**ANGEL PLACE
LEVEL 8, 123 PITT STREET
SYDNEY NSW 2000**

WATERLOO METRO QUARTER - SOUTHERN PRECINCT SSD DA (SSD-10437) | RESPONSE TO REQUEST FOR FURTHER INFORMATION

SECTION 1 1:50
COMMUNAL TERRACE - STUDENT ACCOMMODATION

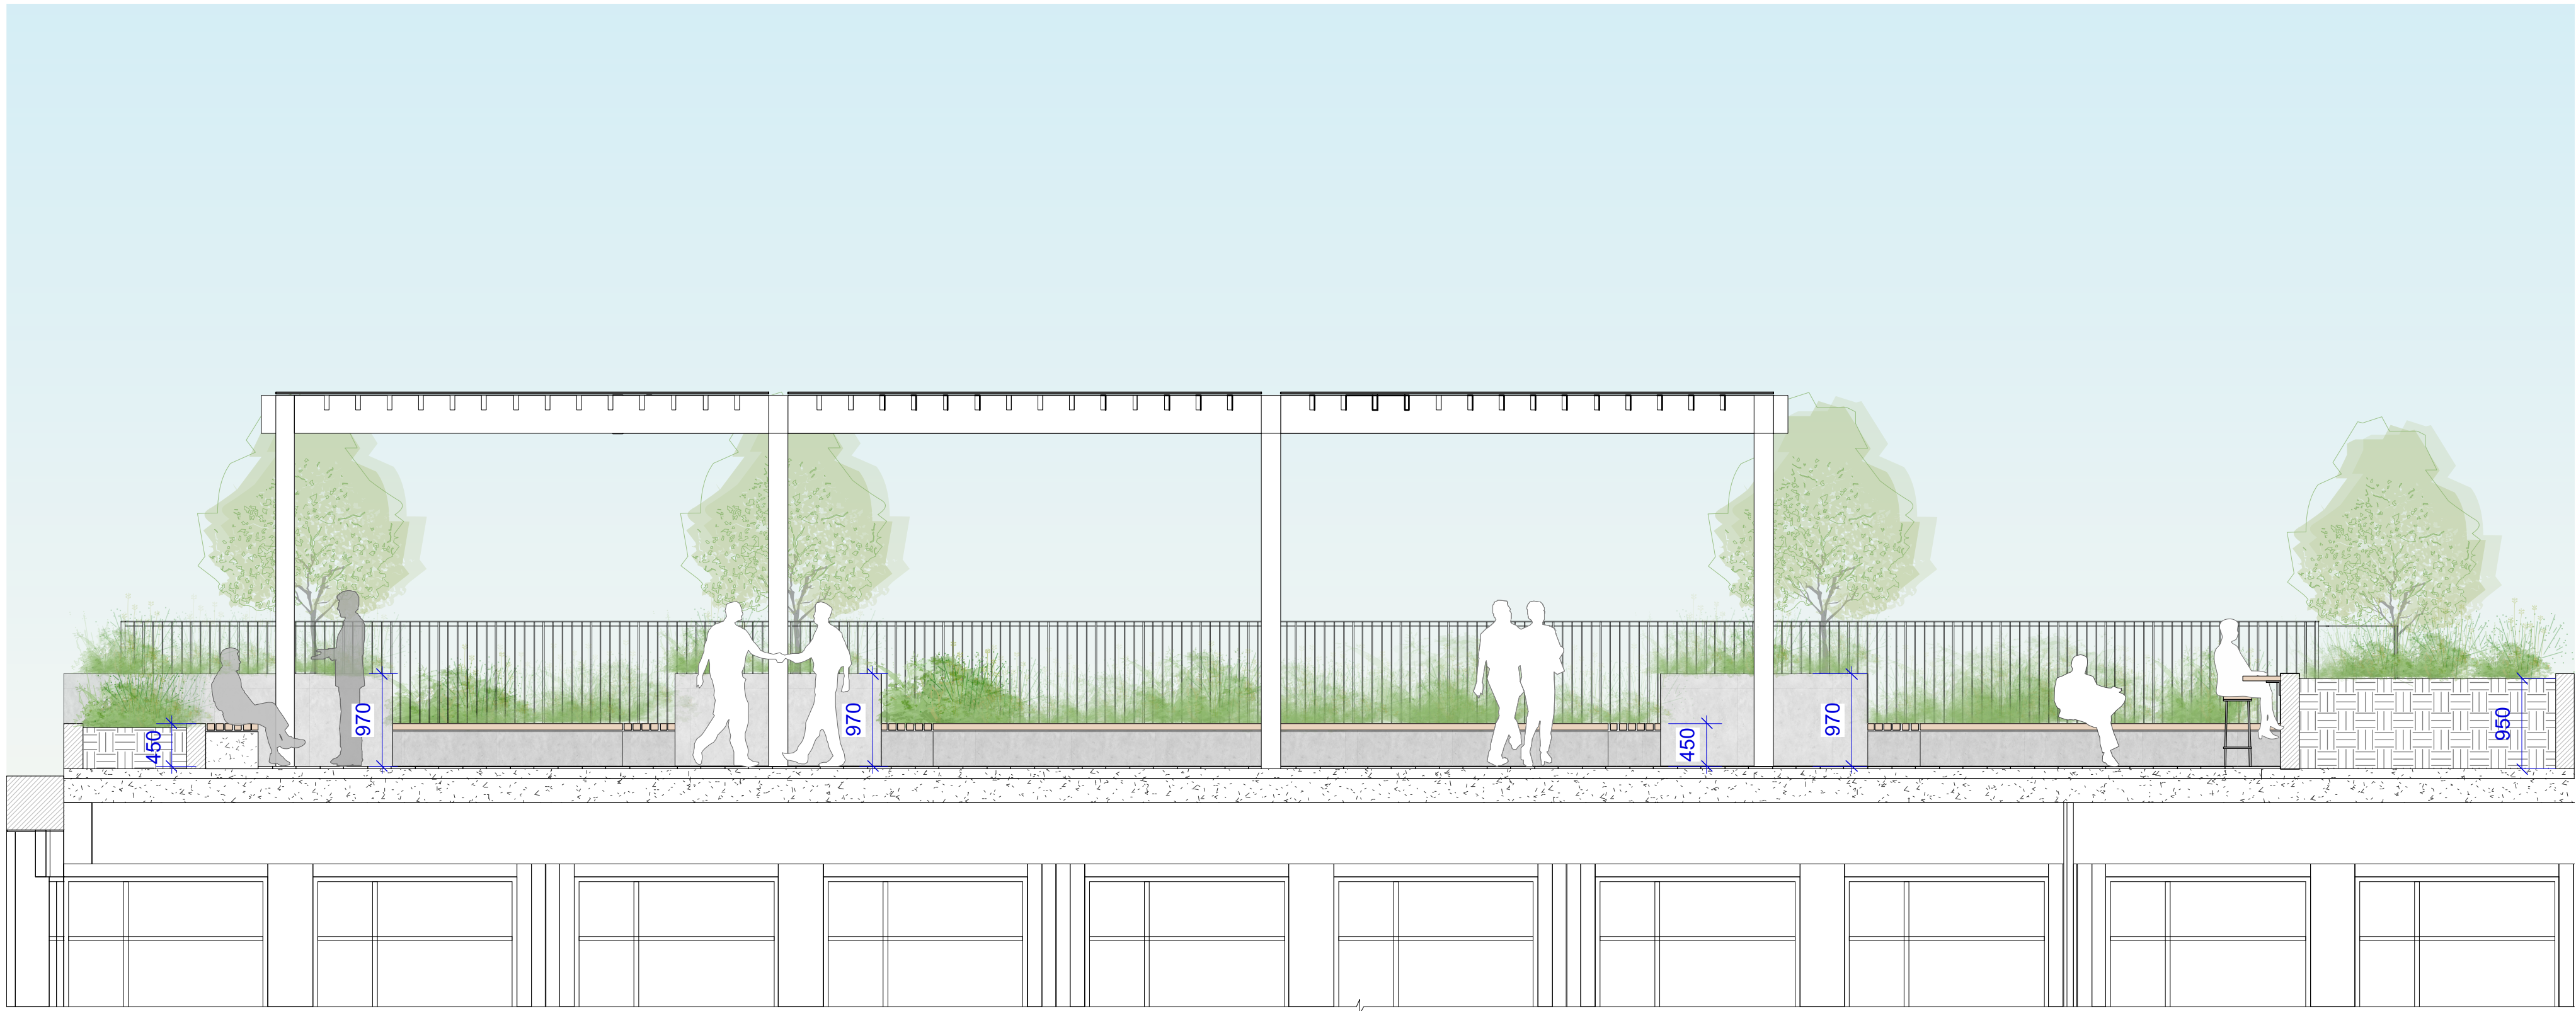
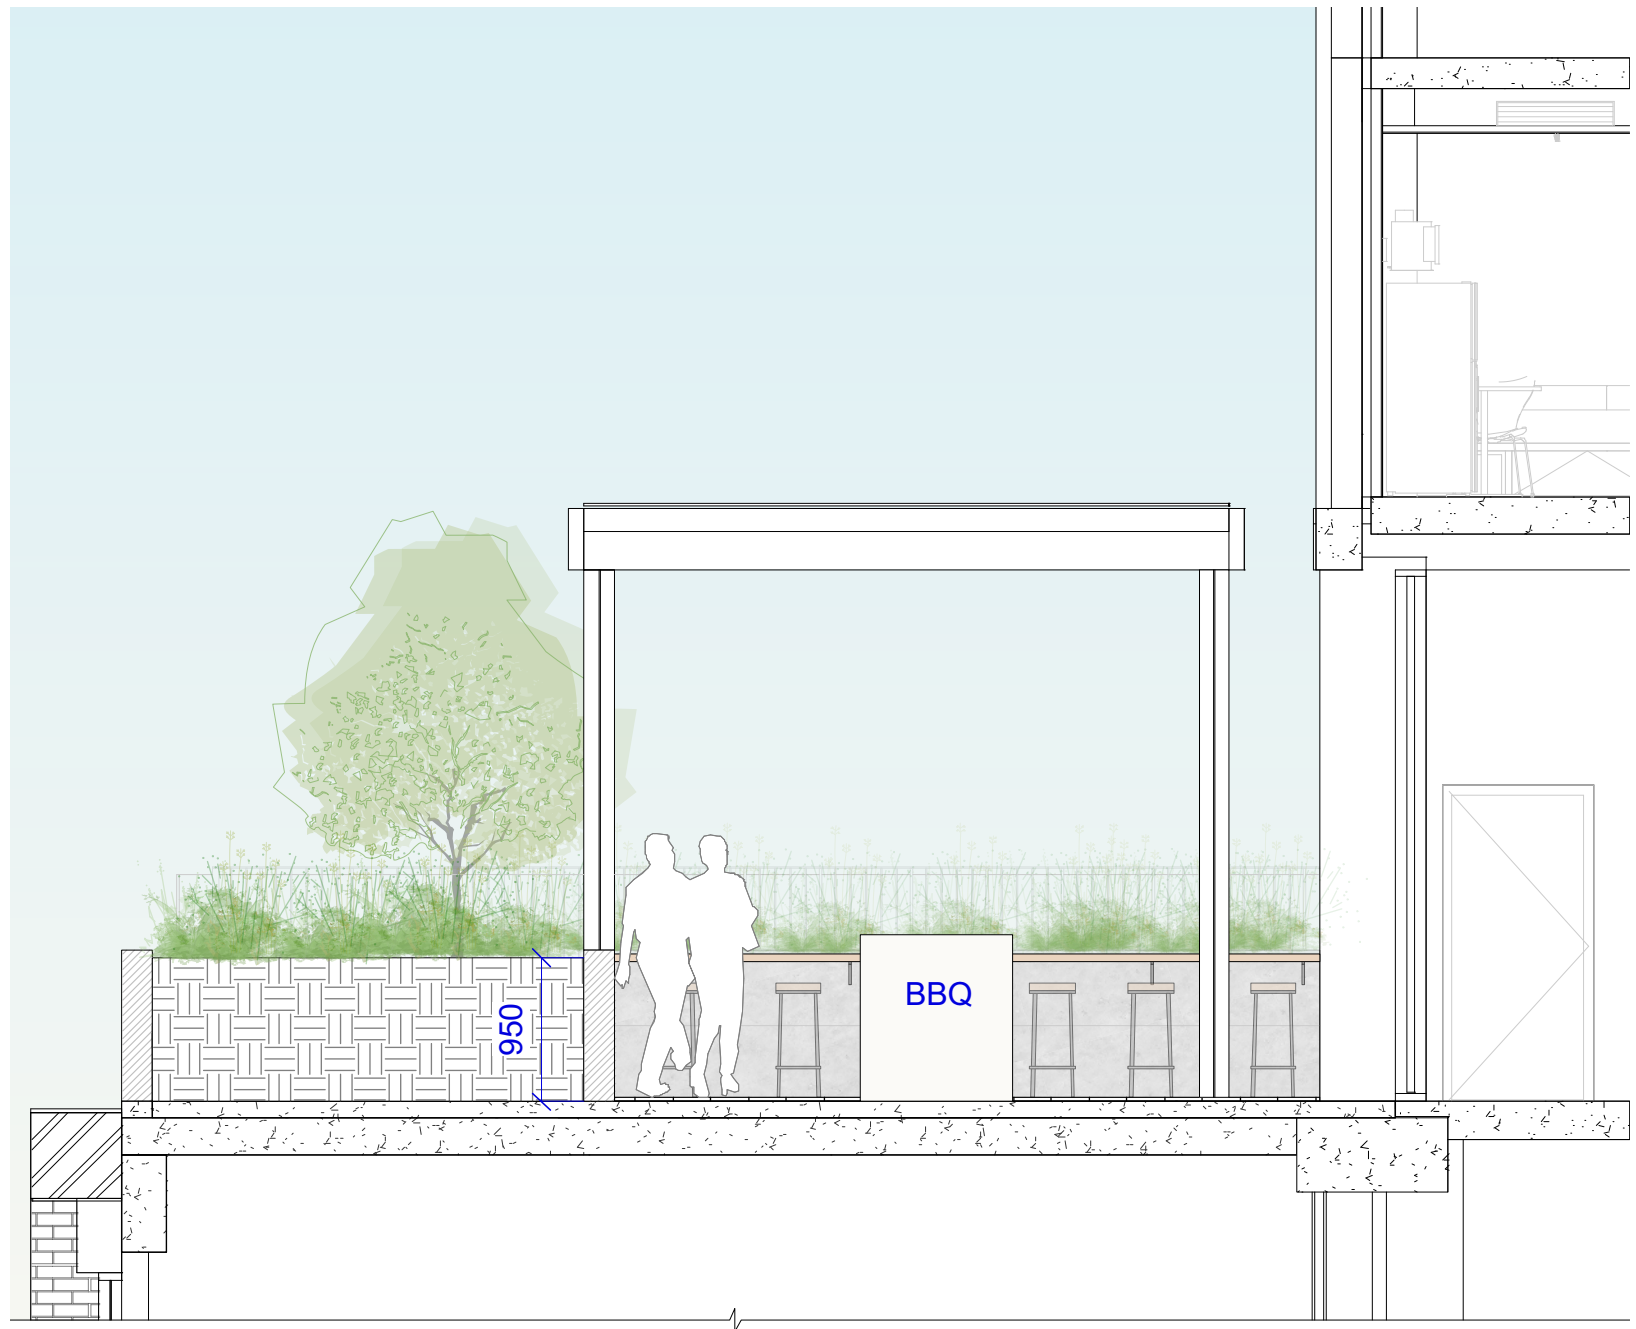
Council have highlighted that the Wind Impact Assessment prepared by RWDI (version 5, dated 15 February 2021) requires extensive tree canopy coverage to meet the wind comfort and safety criteria in order to provide suitable pedestrian amenity. As such, Council have noted sufficient soil volumes and depths are to be provided for each street-tree type.

It is noted that the Wind Impact Assessment recommendations have informed the position of tree planting at key locations in order to ensure a safe and comfortable wind environment is provided for pedestrians navigating the site. All proposed tree planting in these locations will be provided at grade within deep soil areas that allow the trees access to sufficient soil volumes. Aspect have advised that the tree positions and "rootballs" have been coordinated with below ground services to ensure that all trees reach full maturity, height and canopy width.

The applicant accepts references in the conditions of consent to Council's 'Landscape Code Volume 2'. To this point, Aspect notes that a minimum three metre wide garden bed has been provided to

ensure that tree planting successfully establishes and reaches its full height and maturity, in accordance with the deep soil guidelines contained within the Landscape Code Volume 2.

Proposed Ground Floor Plan

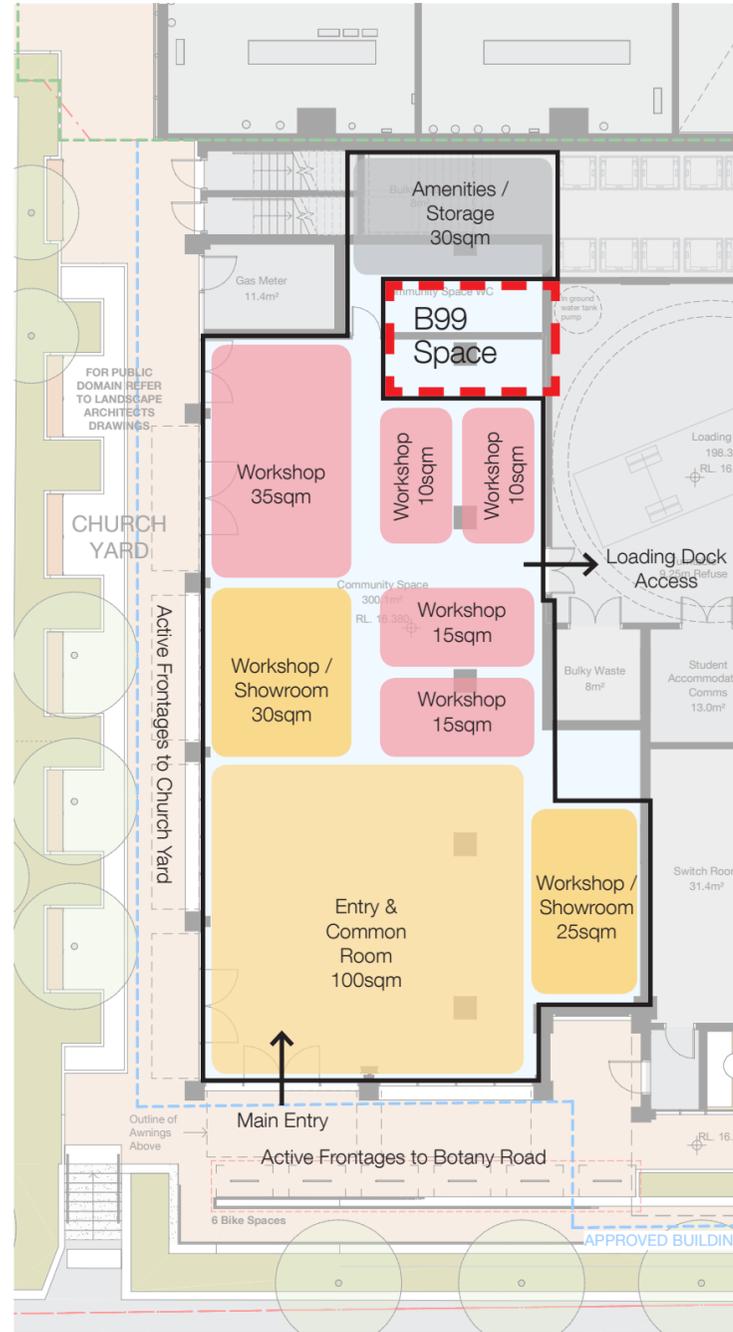
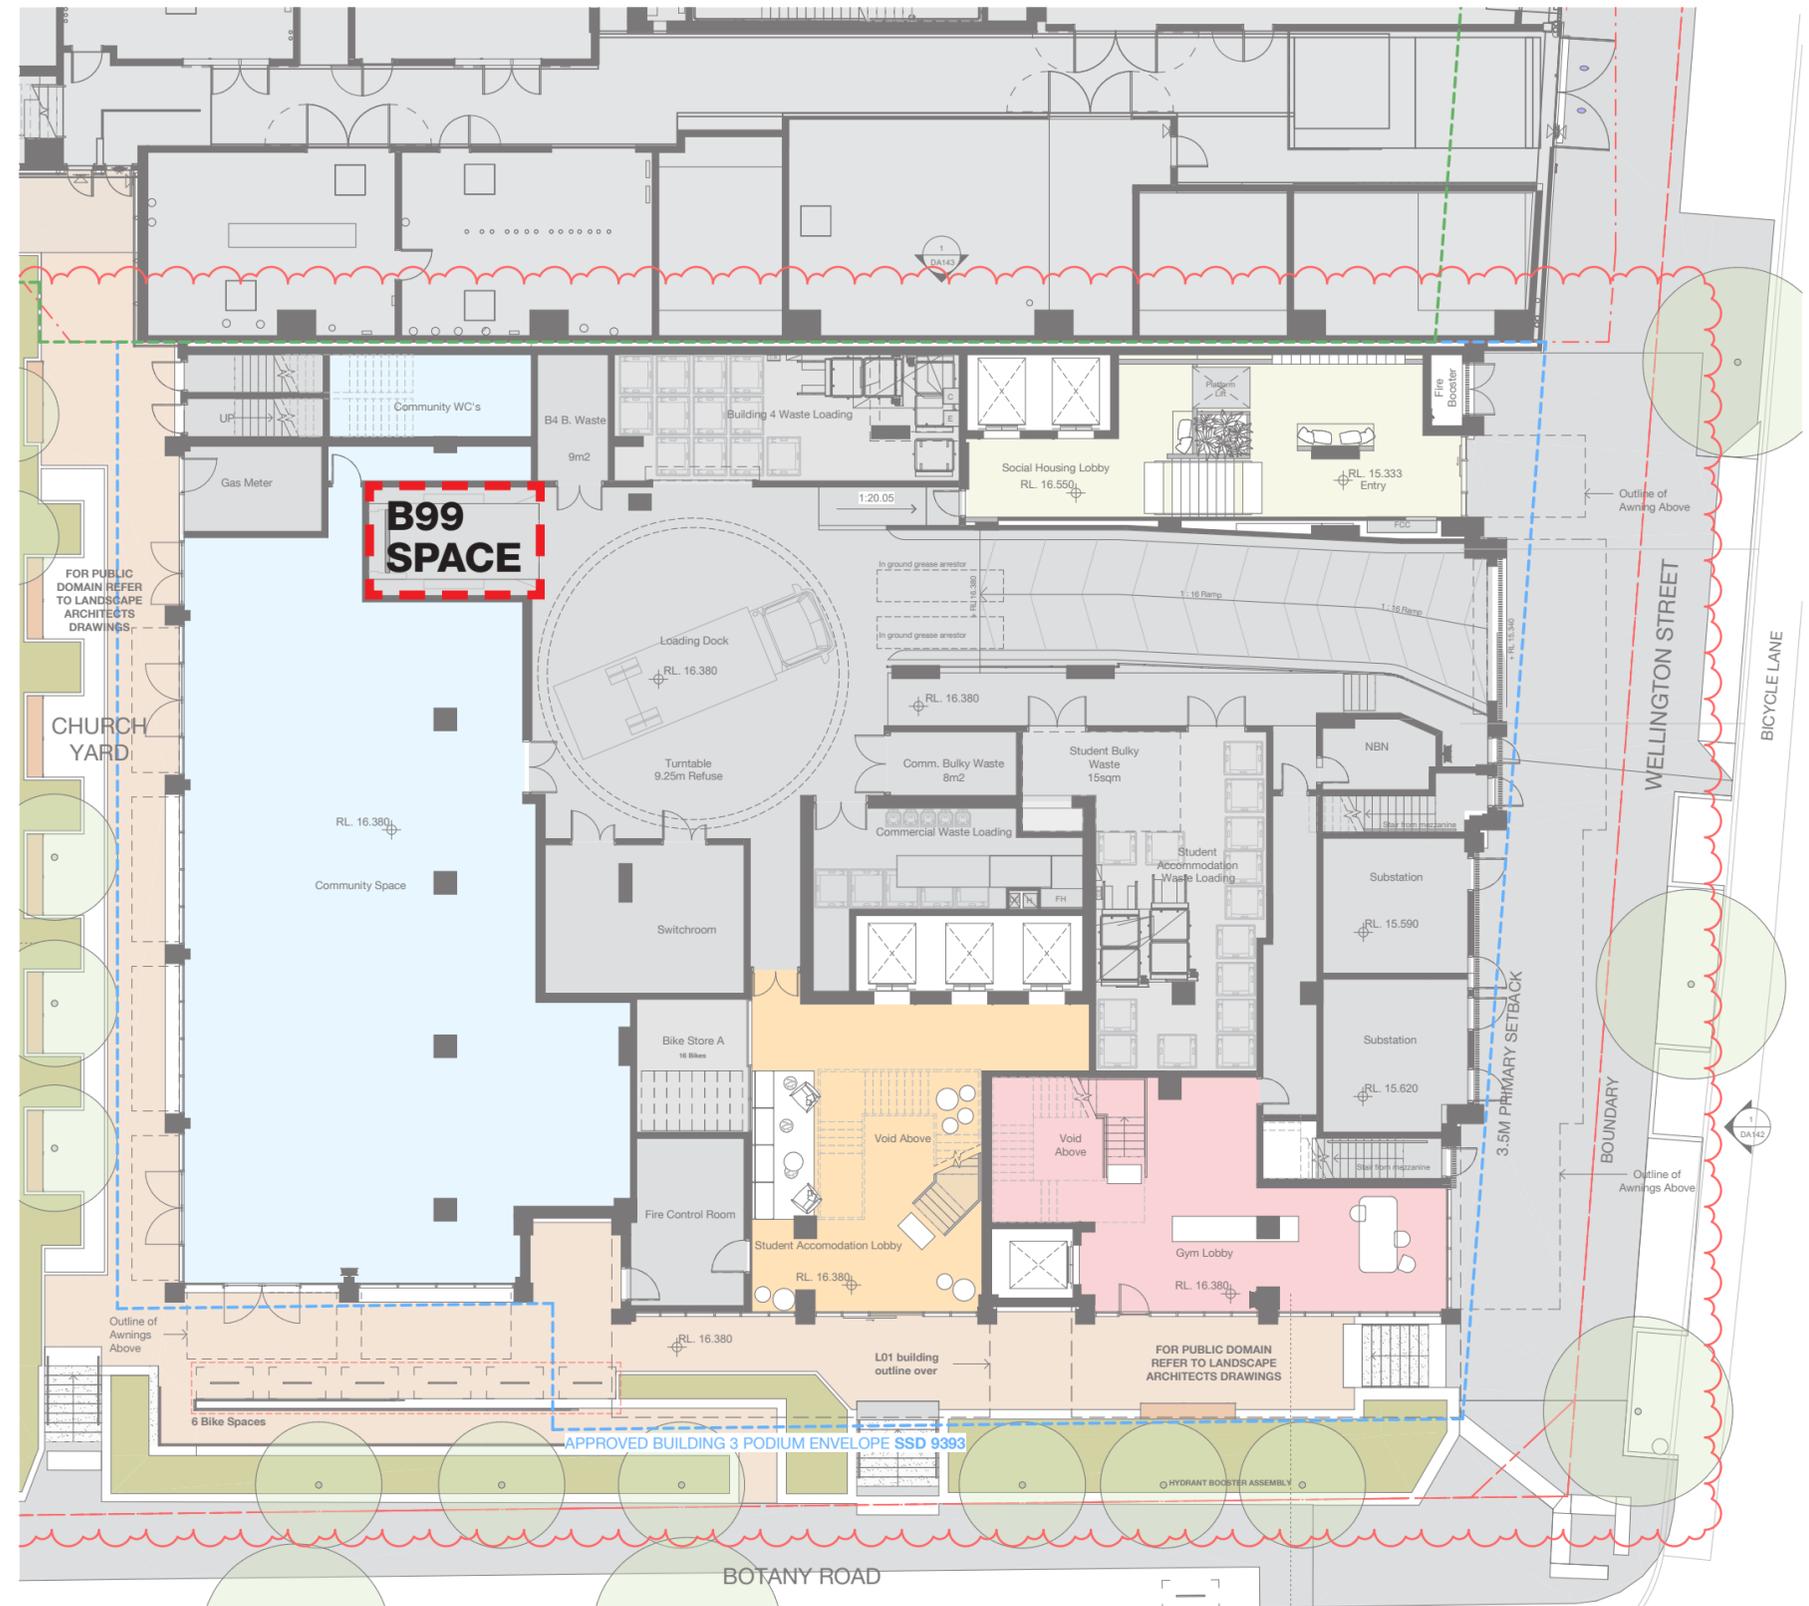
Council have stated that the layout of the Makerspace space is compromised by the addition of a B99 service vehicle space and have requested clarification on the design, operation and securing of a Place Manager.

Due to the servicing and back of house requirements for the four building occupants (i.e. student accommodation, social housing, makerspace and gym), ground floor space is constrained. Accordingly, the B99 space has been co-located with the loading dock to consolidate similar uses and to limit the number of vehicular entries on the façade.

The gym area on the ground floor is relatively modest in space and will serve as the gym lobby, reception and circulation space. It is anticipated that the Makerspace area behind the B99 space will be used for ancillary functions such as toilets and storage. As such, the proposed layout of the Makerspace is considered suitable for the use and a functional layout.

### 15. Blank Side Walls

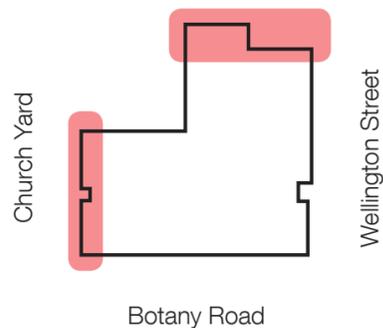
Council have accepted the proposed additional glazing on Building 3 in response to earlier feedback received, however have recommended treating the infill panels on the north and east walls with some variety in colour by way of conditions.

As outlined in the Architectural Design Memo prepared by Bates Smart at **Attachment A**, the design of the building has been developed in response to feedback from the **DRP**. The proposed façade design has sought to strike a balance between built form articulation, fenestration, and architectural expression through the expressed grid frame.

A simple and elegant approach is proposed, in keeping with the overall building architecture, as opposed to a variety of panel colours.

The design of the respective façades has undergone a rigorous design review process in conjunction with the **DRP** where this matter was discussed. The Panel supported the additional windows proposed to the studios to break up the eastern façade blank walls.

Given this, it is considered unnecessary to condition colour changes to the side walls as it would undermine the design integrity of the building and the detailed review process undertaken in consultation with the **DRP** where this design element was endorsed.
